**Consultation Response from KC Policy****2023/90421 Commercial Inn, 43, Church Street, Paddock, Huddersfield, HD1 4UB****Conversion of public house to create 5 flats and 2 retail units and associated works****Date Responded:****Responding Officer: NR****Responding Ref:**

GROUND FLOOR PLAN

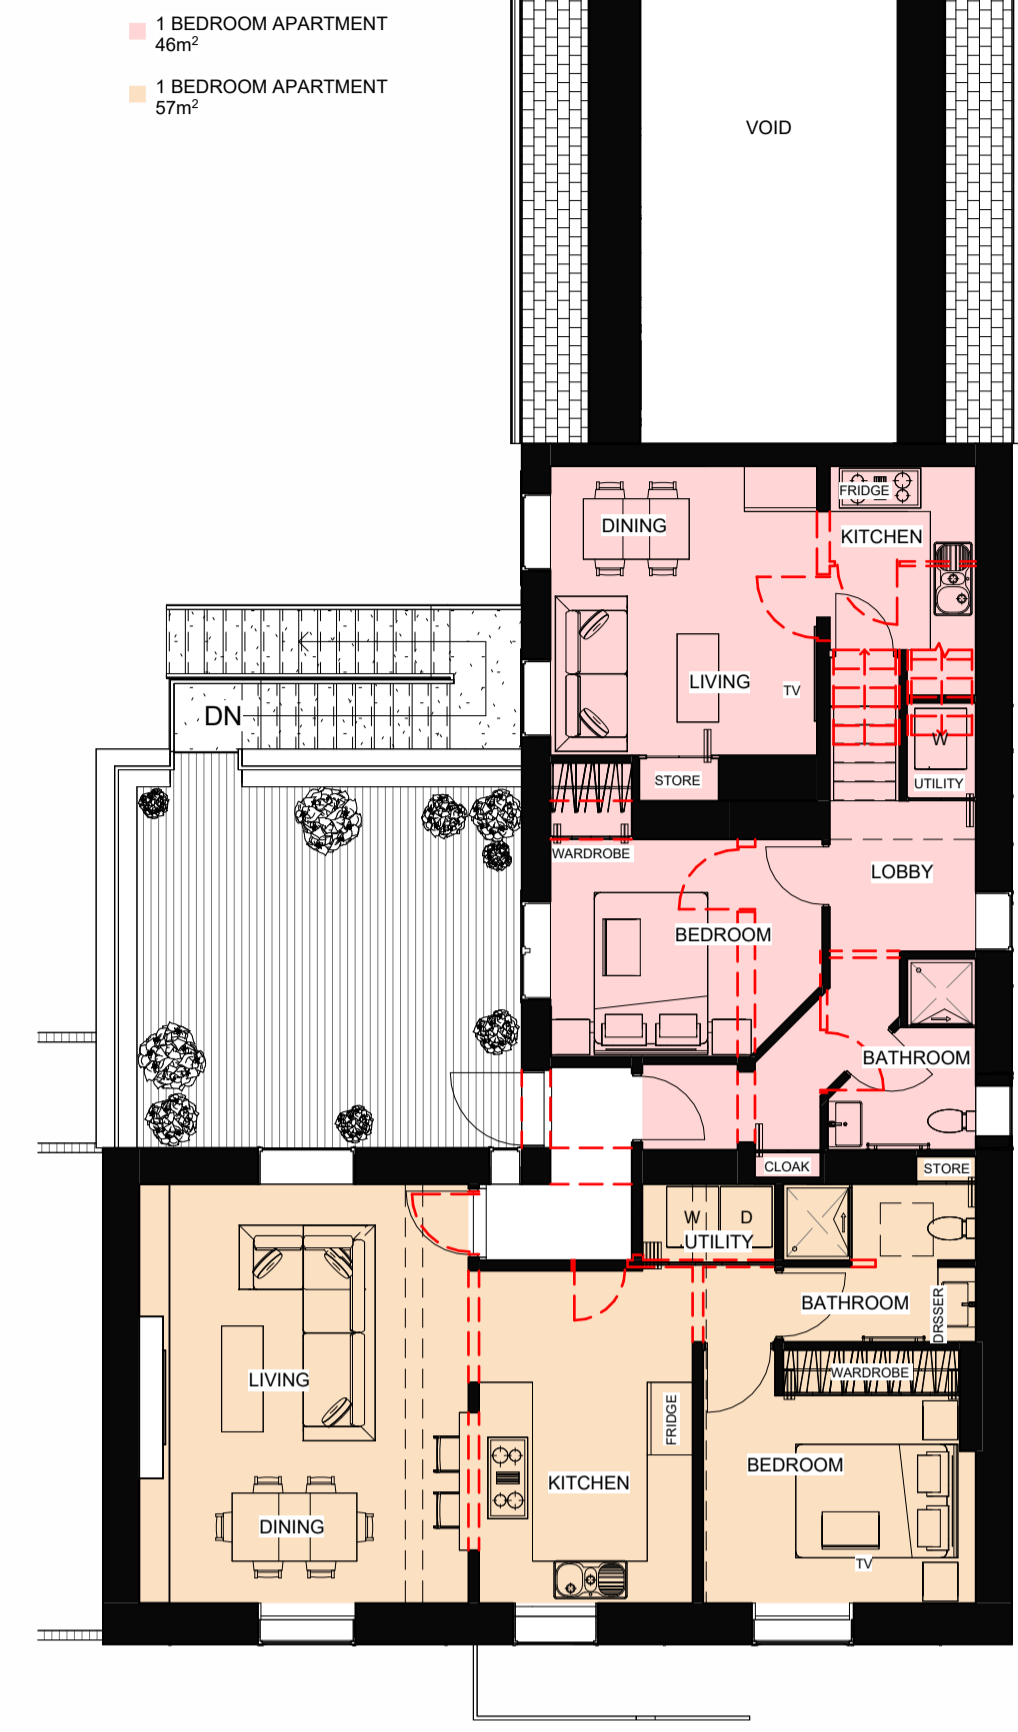
Policy comments on Principle 16 in the Housebuilders’ Design Guide SPD have already been provided on the basement and first floor apartments so the amended proposals for the ground floor only need to be considered in this instance. With the ground floor apartments:

- The two-bedroom apartment would exceed the space standard for a single-storey two-bedroom apartment dwelling 4 residents.

- The three-bedroom apartment would meet the space standard for a single-storey, three-bedroom dwelling accommodating 6 residents.
